**WINDERMERE
PRELIMINARY PLAN**
N. MARKSHEFFEL ROAD
EL PASO COUNTY, COLORADO

**PRELIMINARY
EROSION CONTROL
PLAN**

EC02

EC02

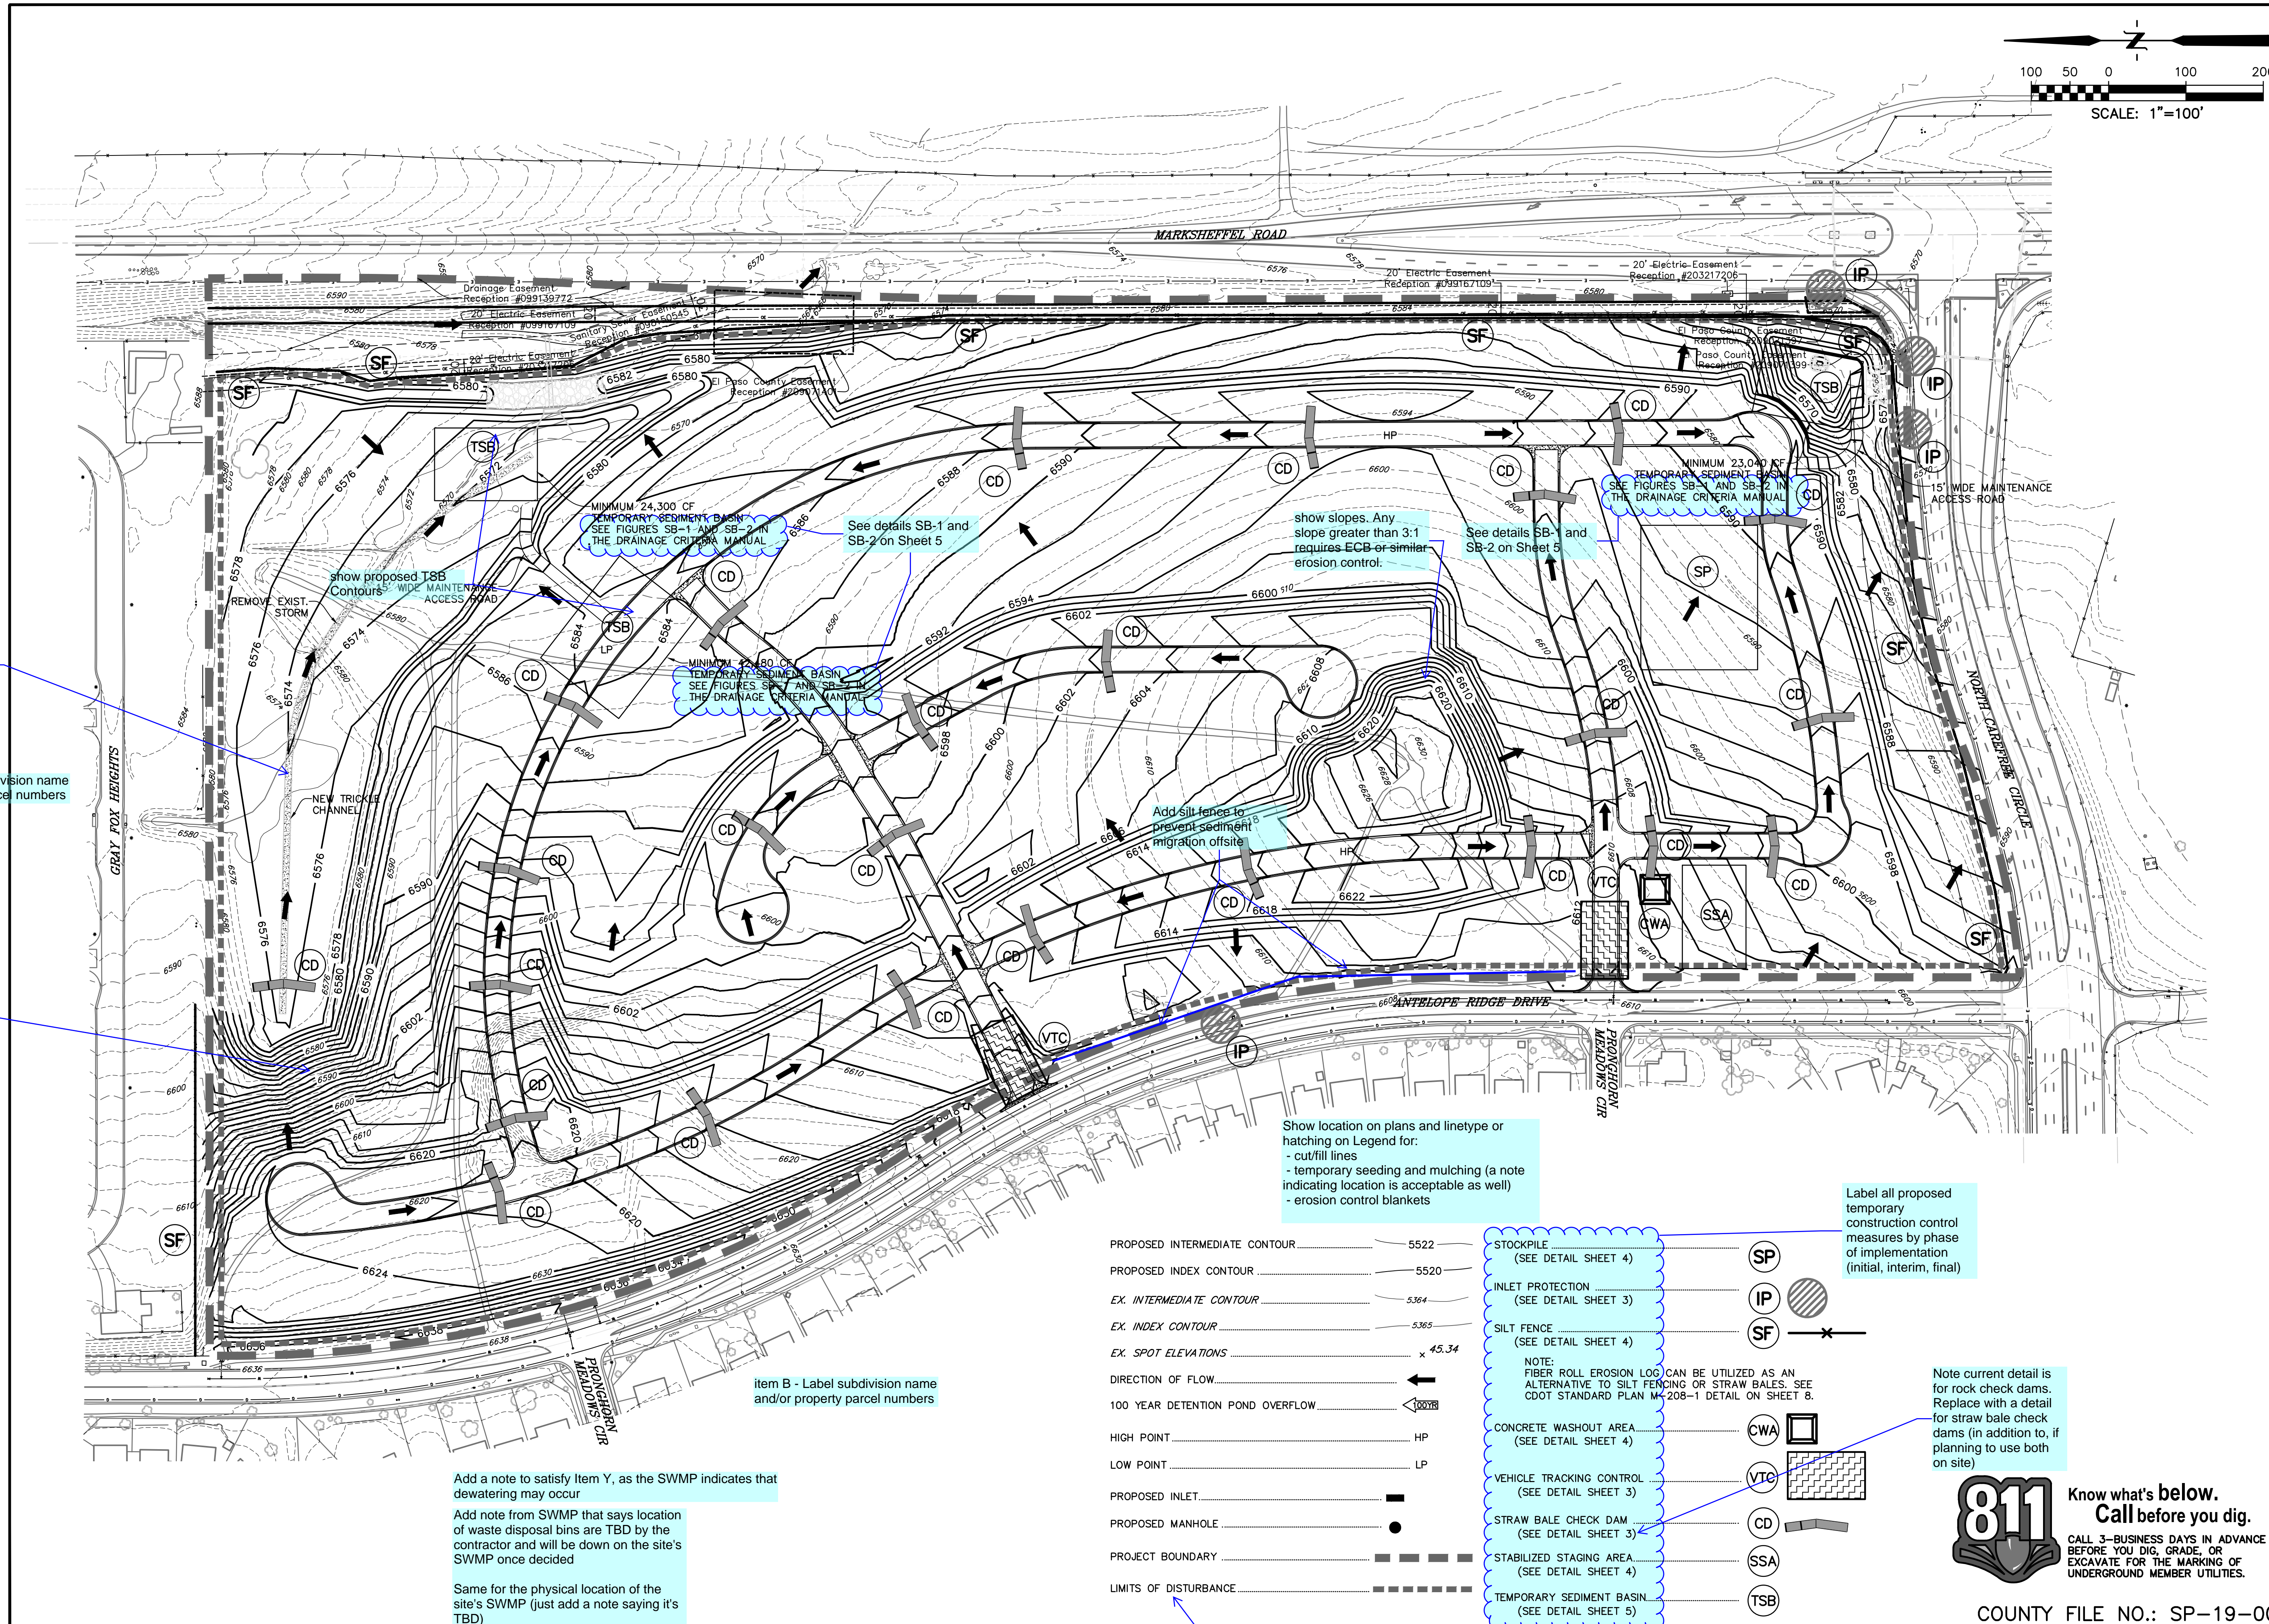
Label all features being constructed and removed.

Show spillway erosion protection.

Use a "hidden" or dashed linetype for existing contours.

no construction access from Marksheffel
